**WEST SUSSEX COUNTY COUNCIL
STRATEGIC PLANNING CONSULTATION**

DATE: 06/04/2017

SUBJECT: EP/41/17/PL - 1 No. dwelling & dormer to front elevation & velux roof windows to rear roof slope to 4 Beechlands Cottages.

Land adjacent to, 4 Beechlands Cottages, Beechlands Close, East Preston, BN16 1JT

Site Plan

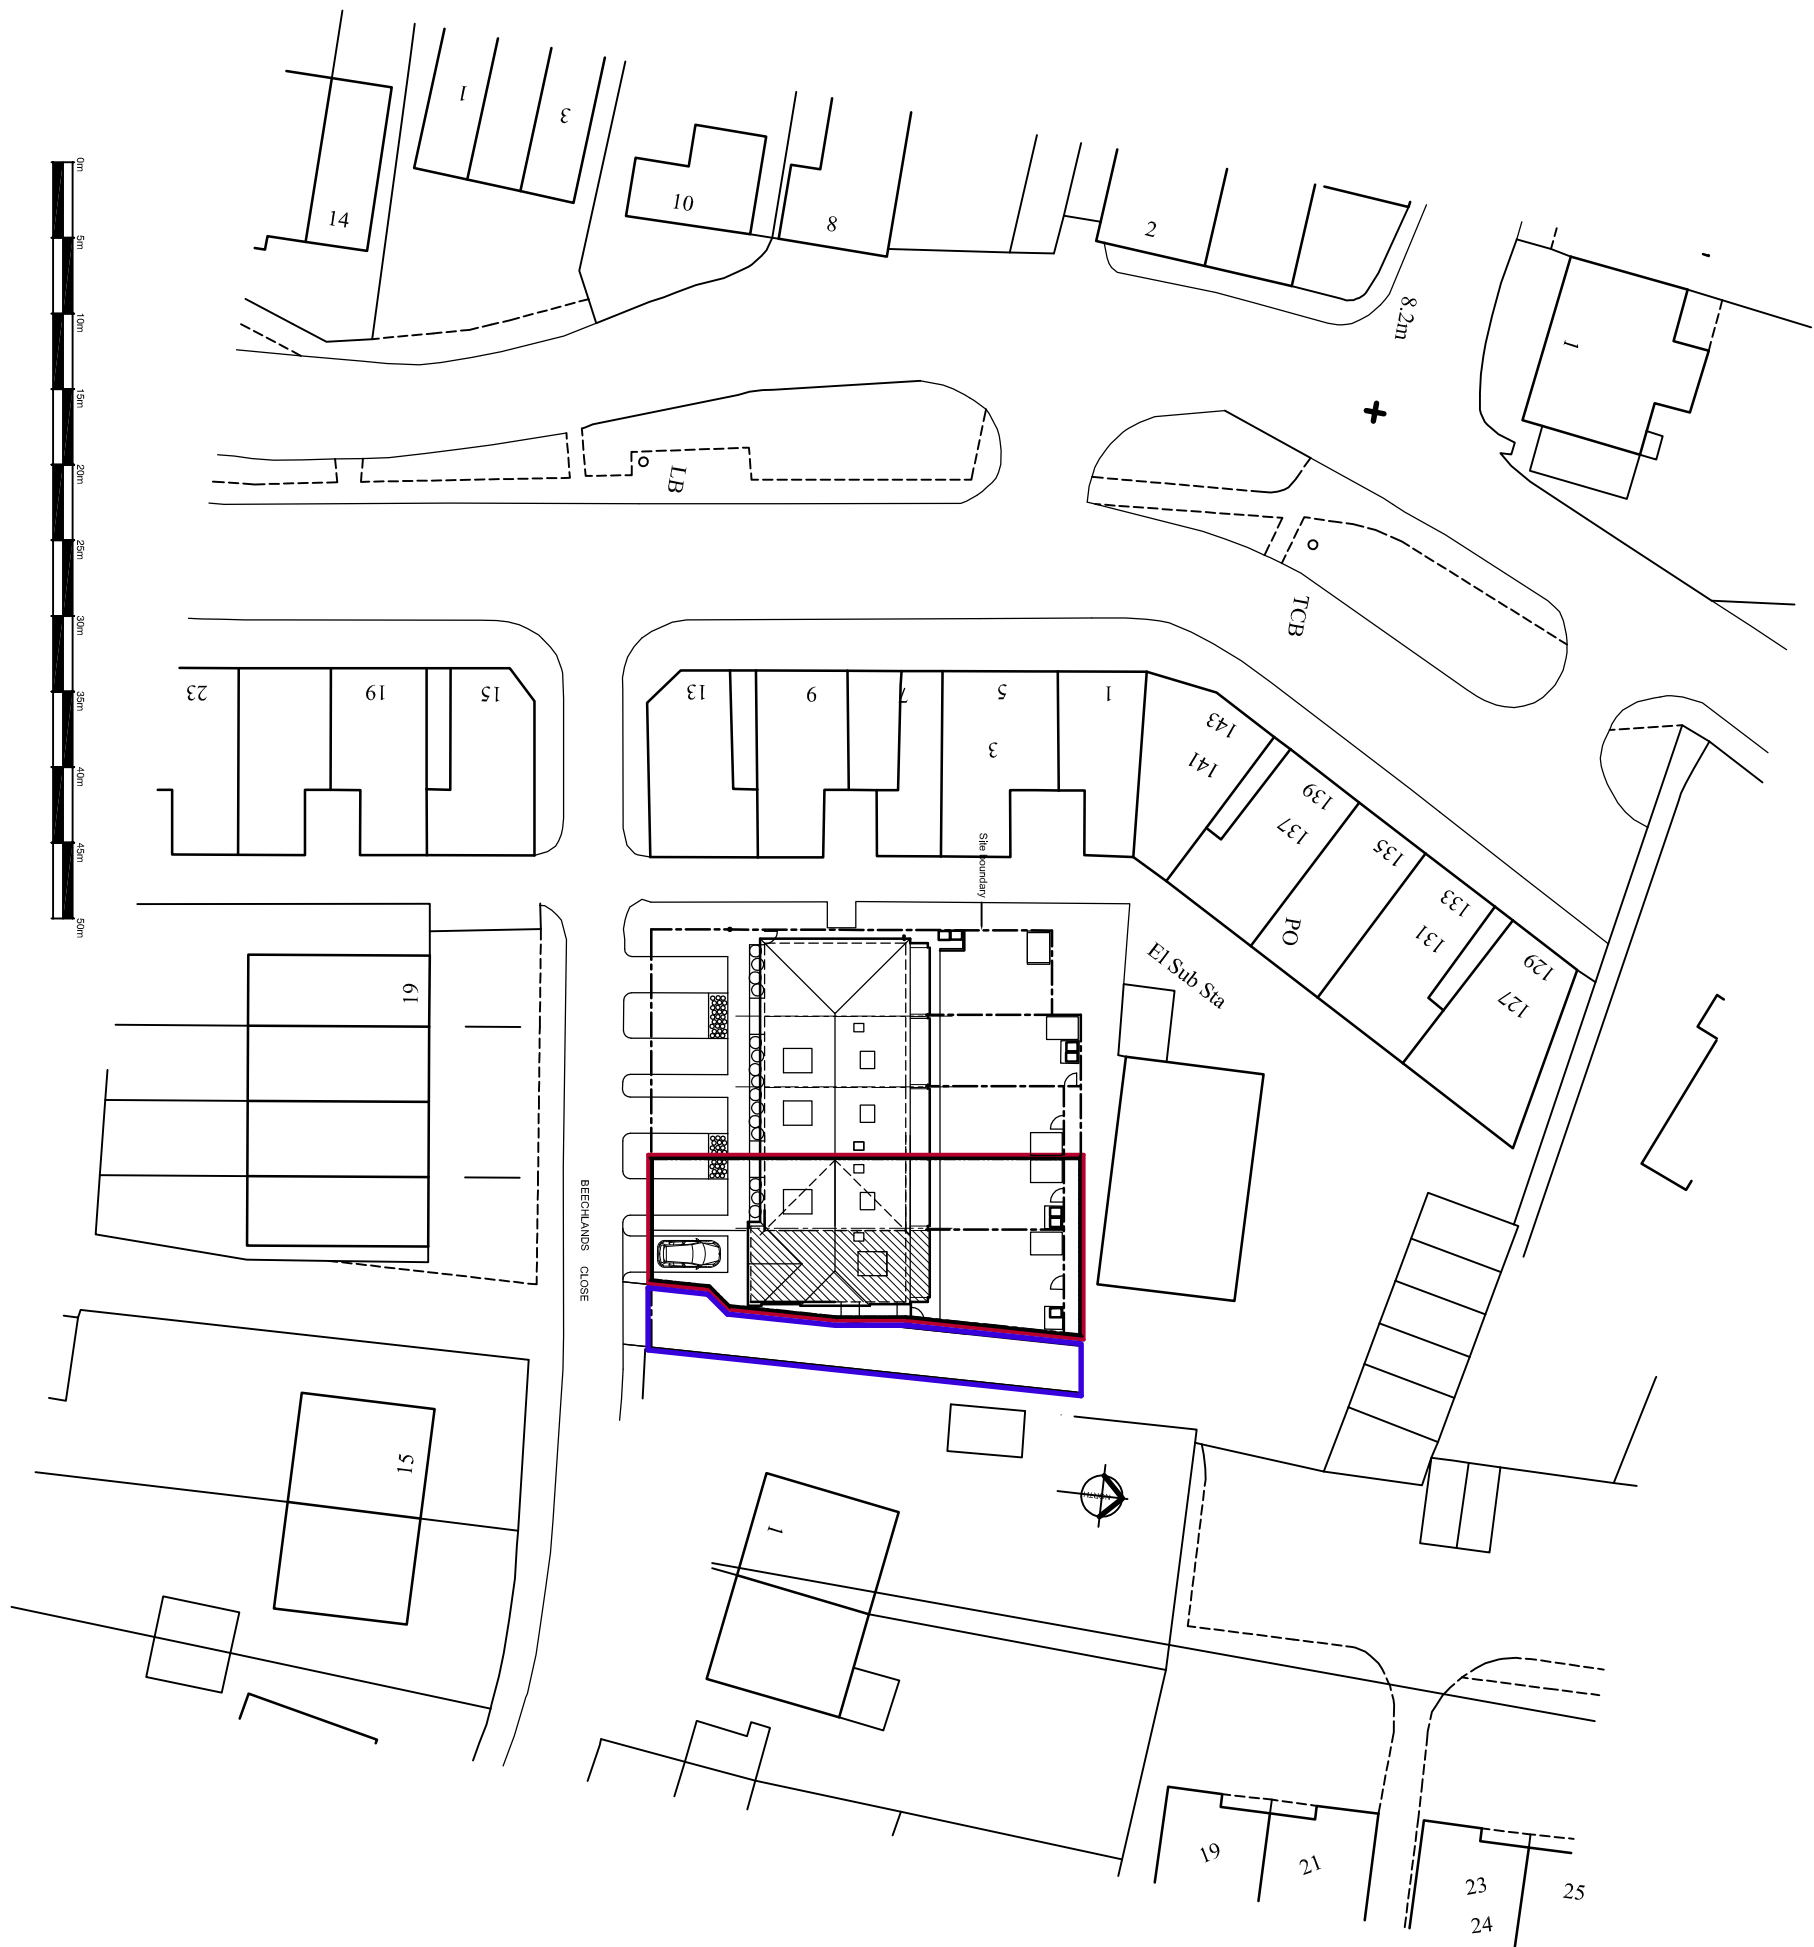
The existing side access to the garages at the rear will be retained though the available width reduced. Nevertheless it will still be sufficient in width for a single car to access the garages to the rear. Considering the low level traffic generation anticipated from these existing garages the Local Highway Authority (LHA) consider that a chance of conflict between vehicles travelling in opposing directions would be negligible. Furthermore, there is sufficient width to pull in off the highway at the entrance and wait in the event a car was exiting at the same time.

From an inspection of the plans and local mapping the existing terrace benefits from an extended dropped kerb along the frontage with single off street car parking spaces fronting each dwelling. The proposed dwelling will be served by an existing single off street car parking space and no further works onto the highway will be required.

Under WSCC Car Parking standards the LHA would envision demand for two car parking spaces for the proposed dwelling. Whilst space nearby on street for parking is limited the nearby Beechlands Close junction with Sea Road is protected by way of double yellow lines and therefore the LHA do not consider that additional on street parking as a result of the development could occur in locations that would be deemed detrimental to highway safety.

Car parking space (details approved)

No part of the development shall be first occupied until the car parking has been constructed in accordance with the approved site plan. These spaces shall thereafter be retained at all times for their designated purpose.

Cycle Store

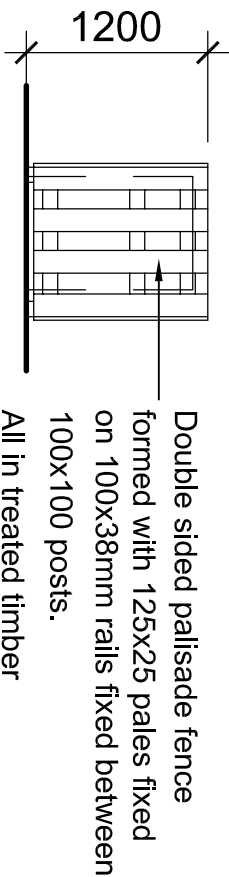
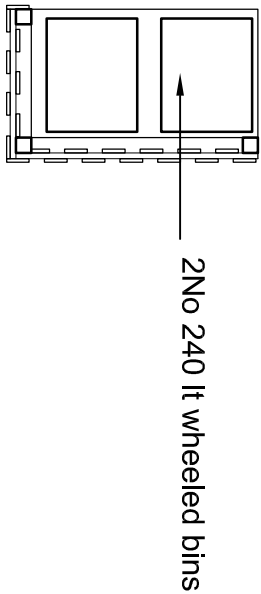
The site is in close proximity to a range of shops, local services and amenities as well as within walking distance of bus stops providing an option for sustainable modes of transport to be up taken. Secure and covered bicycle storage will be provided to the rear and this should be maintained in perpetuity.

Cycle parking

No part of the development shall be first occupied until covered and secure cycle parking spaces have been provided in accordance with the approved plans.
